Florence House

Site Plan Application

Date: Prepared on: October 23rd, 2007
Prepared for: October 23rd, 2007 Planning Board Hearing

Re: Florence House, vicinity of 190 Valley Street
APPENDUM #1

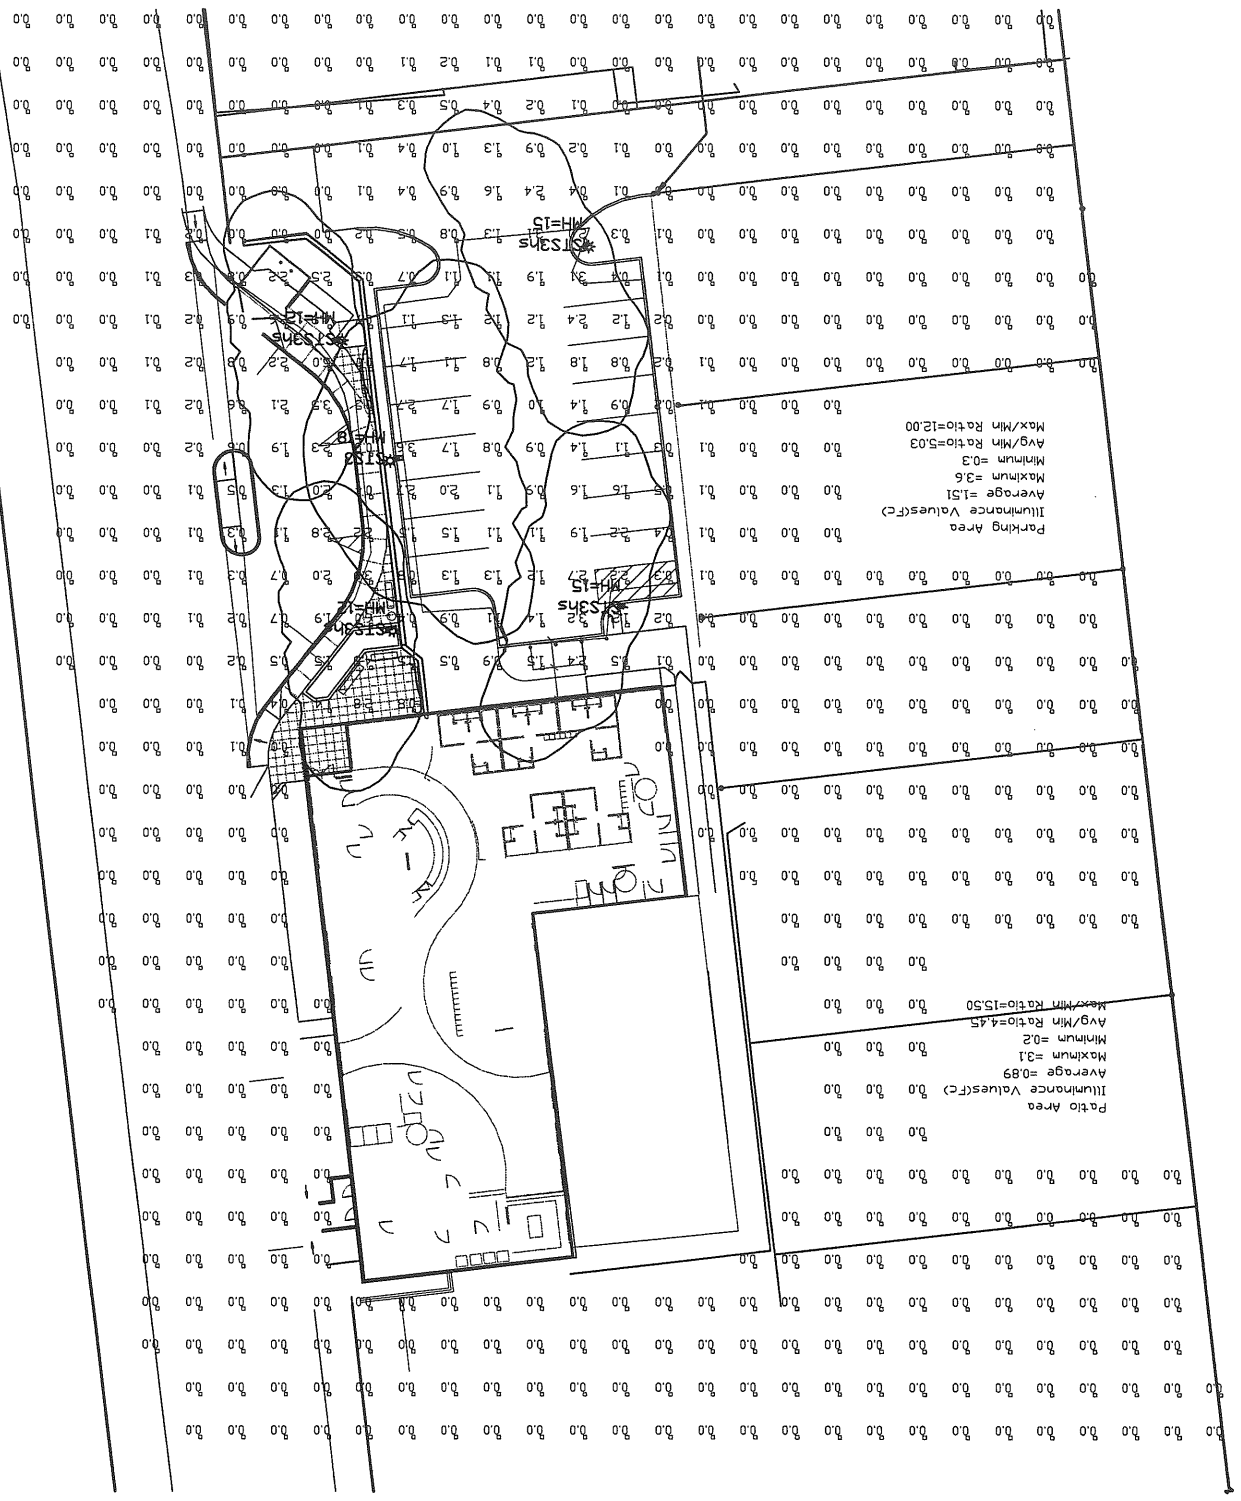
Condition ix: Re lighting trespass near neighbors: the updated photometric has been submitted, which takes account of the 4 foot high fence, and shows that there is no trespass along the boundary with residential abutters.
